A1 in Northumberland: Morpeth to Ellingham

Scheme Number: TR010059

Summary of Proposed Changes to Application

Regulation Reference:	Infrastructure Planning (Examination Procedure) Rules 2010
Planning Inspectorate Scheme Reference	TR010059
Document Reference	TR010059/7.5
Author:	A1 in Northumberland: Morpeth to Ellingham Project Team, Highways England

Indicative Earthwork Change Locations

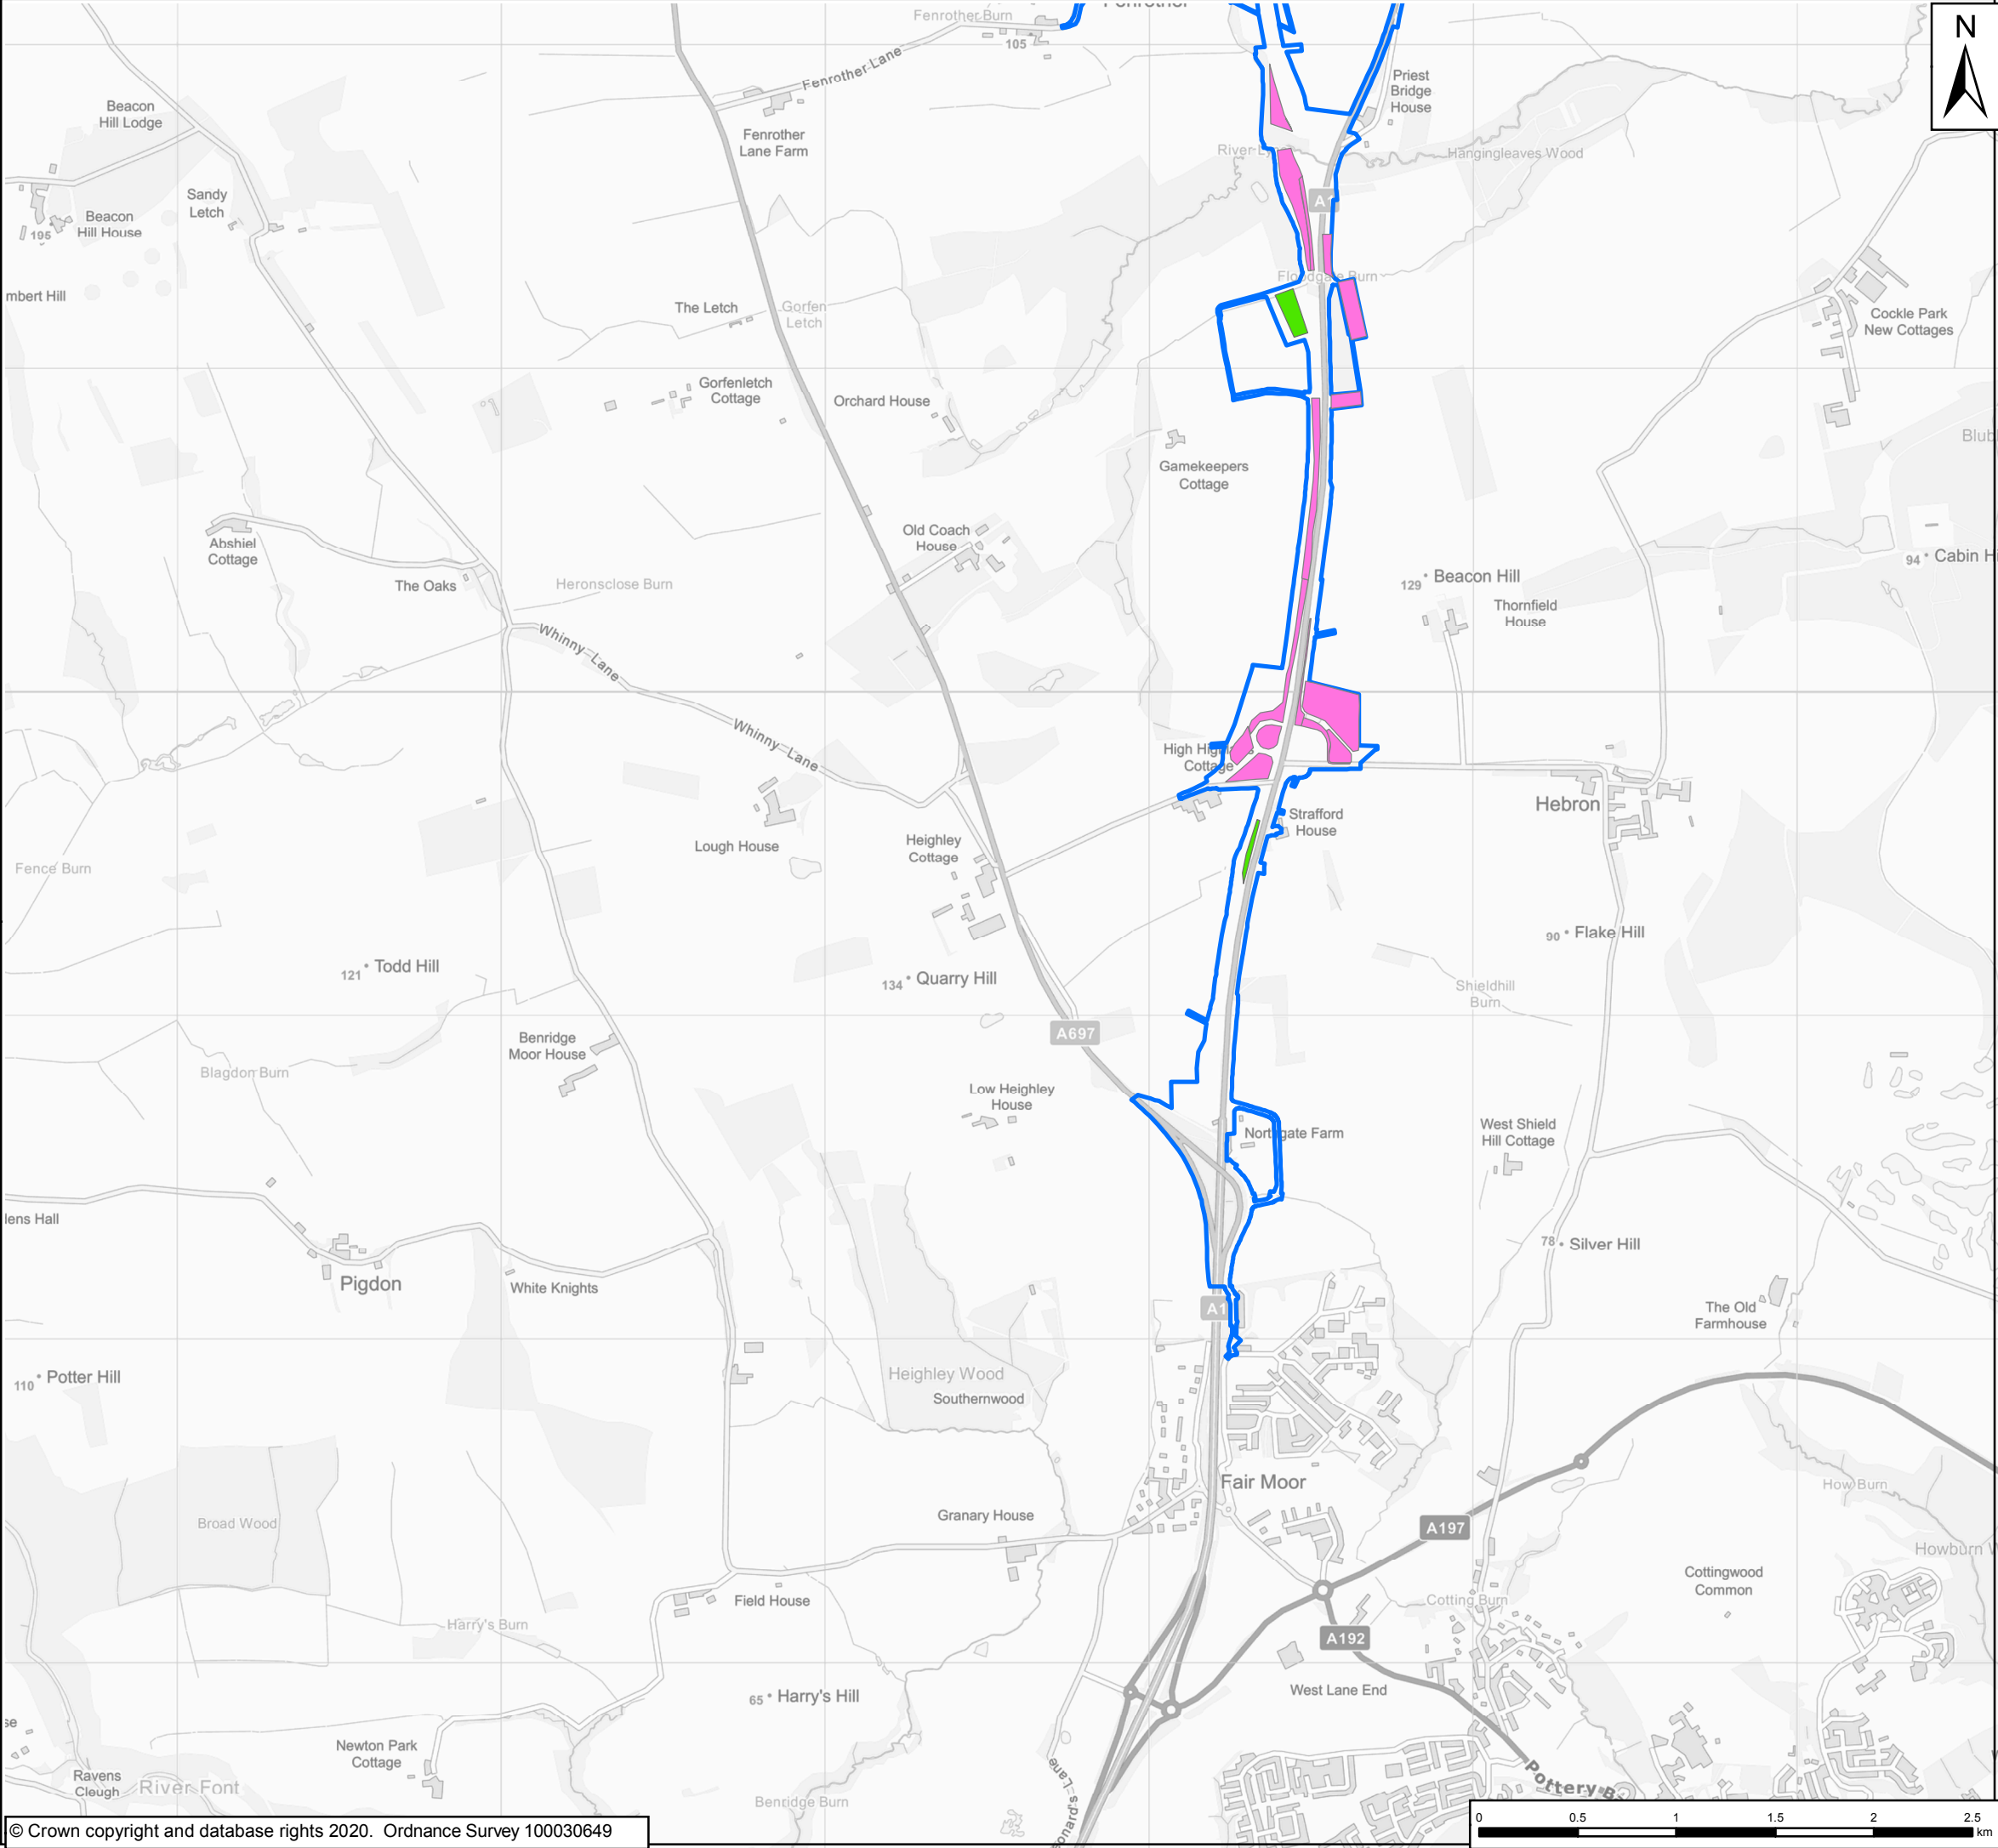
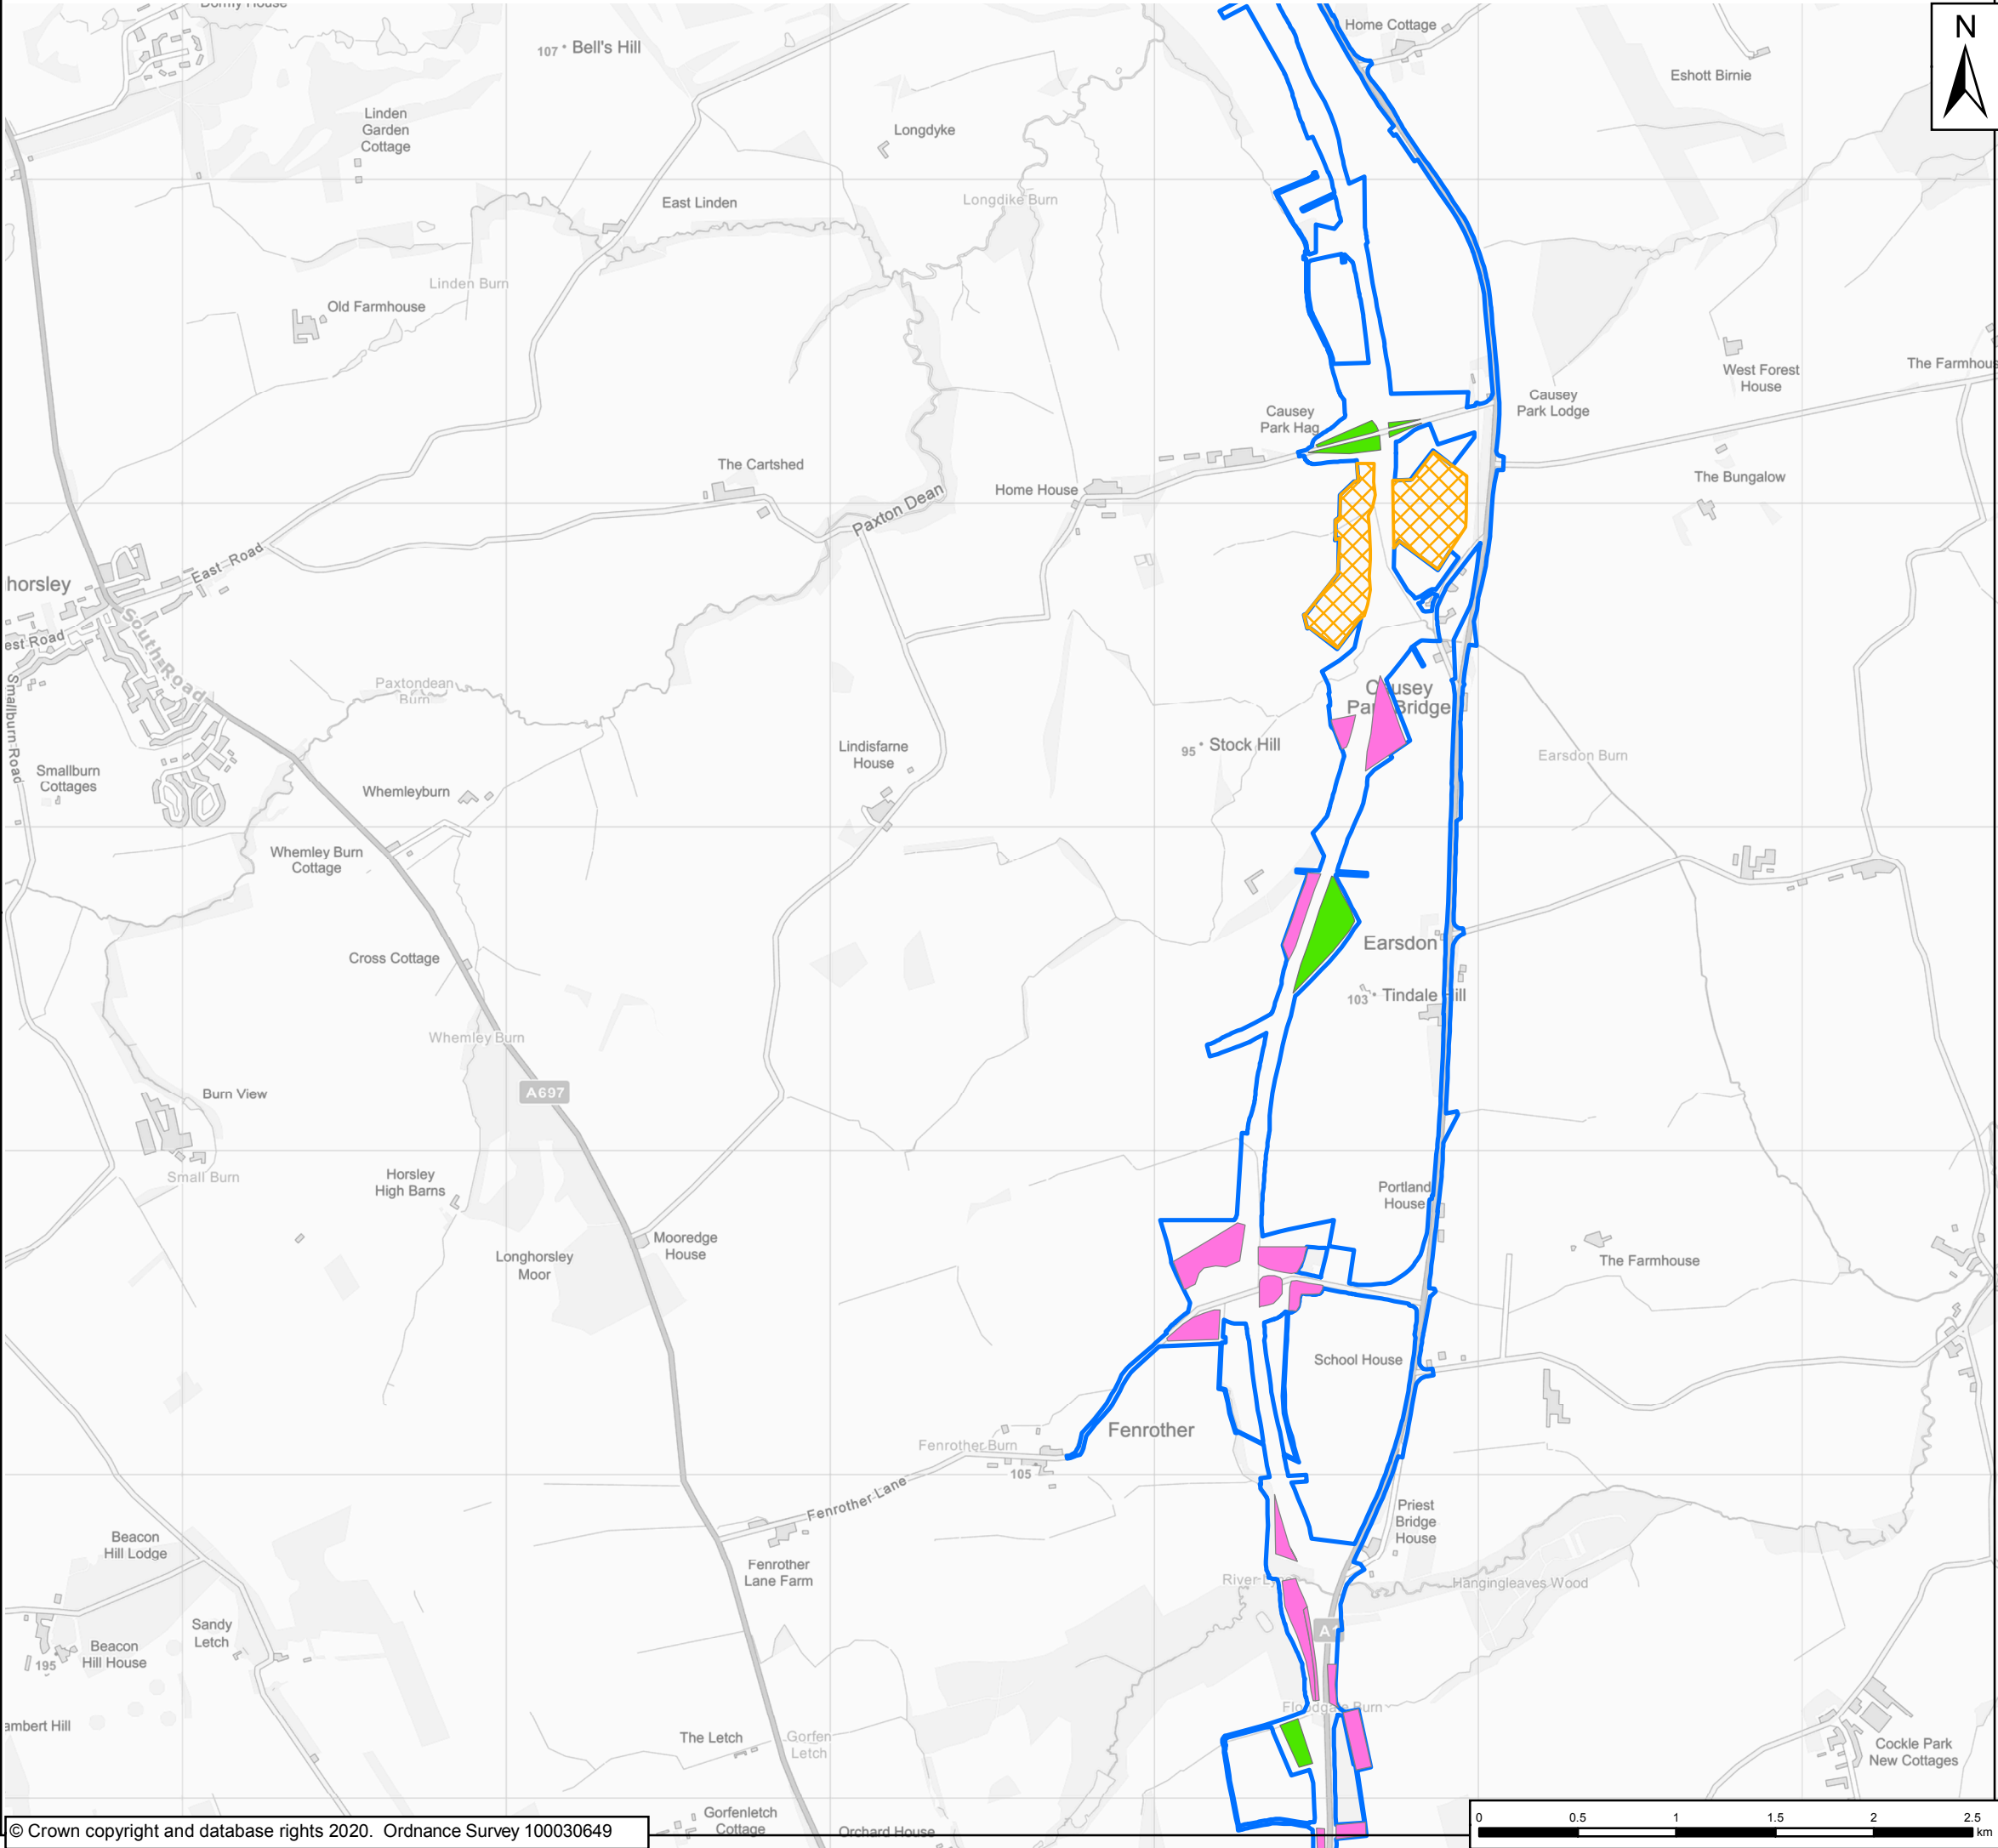
- 2.1.1 The Applicant proposes to maximise the re-use of materials (via excavation, deposition and temporary storage), within the existing Scheme extents. A recent review of the earthworks strategy has identified an opportunity to reduce earthwork movement and as a result greater flexibility in temporary and permanent storage of Site won material is required to achieve this. The indicative earthworks areas are shown in the figure in the **Indicative Earthwork Change Locations** figure in **Appendix A**.

- 2.1.2 To balance materials across both Parts A and B, the following methods are proposed:
- Utilising borrow pits to exchange and win additional material suitable for construction.

- Maximising use of soil bunds already specified within the **Figure 7.8: Landscape Mitigation Masterplan** for Part A [APP-095], **Figure 7.10 Landscape Mitigation Masterplan** for Part B [APP-144] and **Figure 7.14: Landscape Mitigation Masterplan including Assessment Parameter 3** for Part B [APP-148], for disposal of excess site material, in Part A.

- Maximising of fill within slopes, already specified within **Figure 7.8: Landscape Mitigation Masterplan** for Part A [APP-095] and **Figure 7.10 Landscape Mitigation Masterplan** for Part B [APP-144] and **Figure 7.14: Landscape Mitigation Masterplan including Assessment Parameter 3** for Part B [APP-148], for re-use of site material, in Part A.

- Creation of new soil bunds within Part B to maximise re-use of excess site material.
 - Maximising of slopes for re-use of excess site material, in Part B.

- Laying down additional material increasing some localised ground levels.
 - Raising levels of junction “bowls” (level or rounded rather than dished).

- Creating new, temporary soil storage areas within both Part A and Part B.
- 2.1.3 These changes are an alteration to Parameters 4 and 5 for Part A, as set out in **Chapter 2: The Scheme** of the ES [APP-037]. There would also be additional temporary and permanent earthworks that require assessment for Part A and Part B. Therefore, it is appropriate to ensure that the environmental information before the Examination addresses the prospect of altered impacts This is addressed by sensitivity testing as described at **paragraph 2.1.6** below.
